**The Morecambe Offshore Windfarm Generation Assets Development Consent Order Application**

**Deadline 6 Submission of Spirit Energy Production UK Limited**

**Responses to the Examining Authority's Request for Further Information (Rule 17)**

<b>Date</b>	15 April 2025
-------------	---------------

**TITLE:** Spirit Protective Provisions Plan

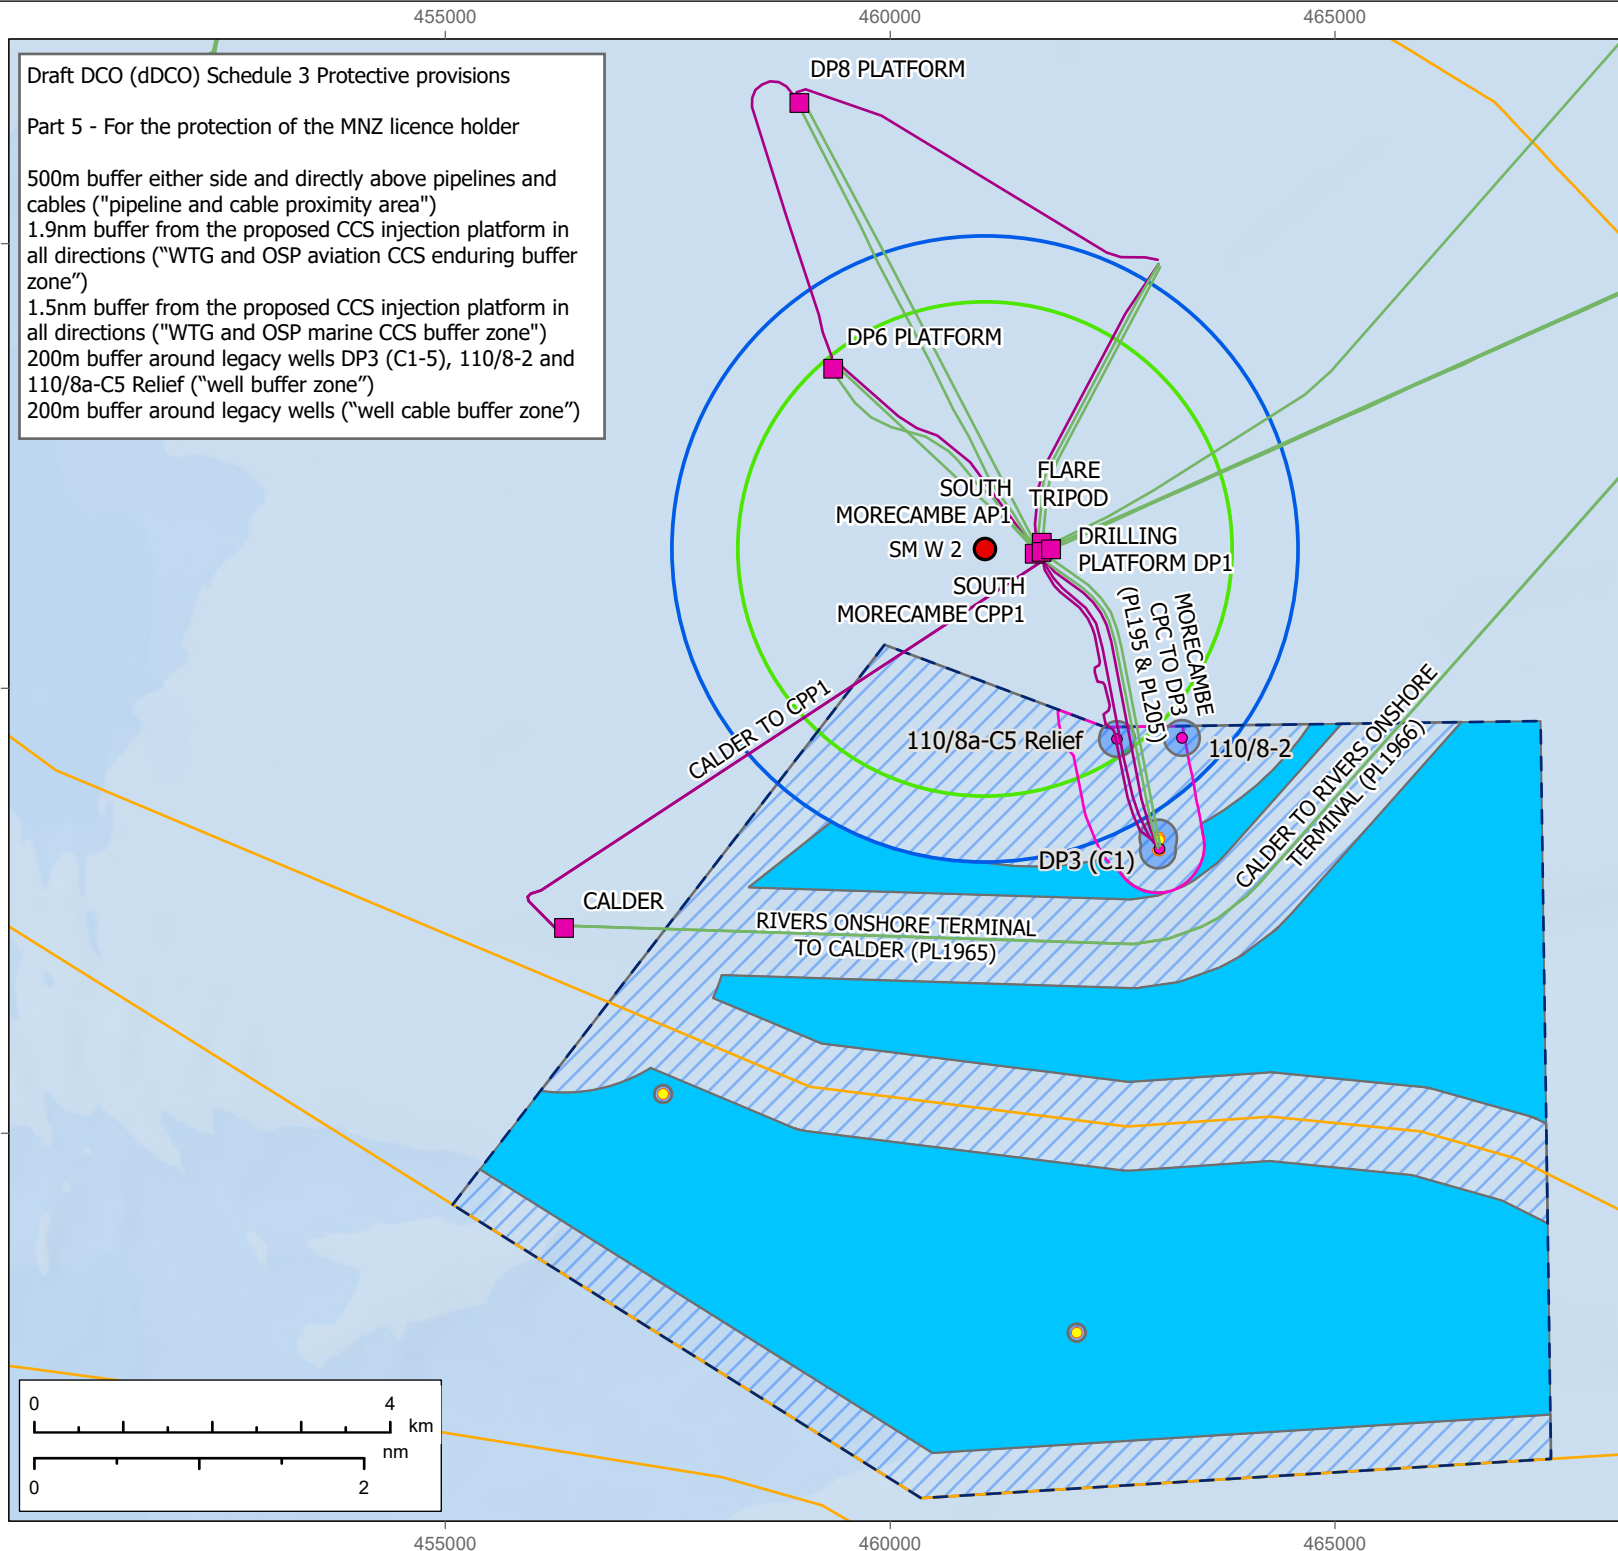
"cable" means the power and telecommunications cables connecting ~~CPPI~~CPC to the DP3 wells shown ~~purple~~pink and annotated as ~~Morecambe to CPPI~~CPC to DP3 on the Spirit ~~and Harbour~~Licence Protective Provisions Plan;

"pipeline and cable proximity area" means the area five hundred meters (500m) either side and directly above the pipeline and cable ~~shown shaded yellow and annotated as the Pipeline and Cable Proximity Area on the Spirit Licence Protective Provisions Plan~~;

"well buffer zone" means a one ~~hundred metre (100m)~~nautical mile (1 nm) radius buffer zone around ~~the following three legacy and relief well tophole locations listed in Table 3—~~each legacy well shown edged with

**Commented [A19]:** 1nm is the minimum distance required to allow rig access to these well locations to carry out works, taking account of anchor/tug vessels and the need to manoeuvre a rig into position. There are no dynamic positioning rigs available in the East Irish Sea. Similar protections are sought by Spirit Energy in the MNZ PPs, since these locations may also need to be accessed in the future as part of any CCS monitoring and corrective measures plan for that well (see the minutes of a shared understanding meeting between Spirit Energy and the Applicant dated 26<sup>th</sup> March 2025 provided with the Spirit Energy Deadline 5A submission).

"WTG and OSP aviation buffer zone" means an area of one three point five seven six nautical miles (1.53.76 nm) of clear unobstructed airspace measured from the outer extremity edge of CPPI to any tip from any wind turbine generator located within the Licence each of the helidecks in all directions and extending vertically from mean sea level shown to its southern extent edged shaded blue and edged grey and annotated and shown as the WTG and OSP aviation buffer zones on the Spirit and Harbour Licence Protective Provisions Plan;

Commented [A23]: The unobstructed buffer zone is required to extend in a 3.76nm radius from each of the helidecks, regardless of the location of WTGs.

Commented [A24]: This buffer is agreed, but Spirit requires that this buffer is around both the AP-1 and DP-1 helidecks.

Commented [A26]: This buffer is agreed albeit Spirit's protective provisions identify the location as the AP-1 helideck.
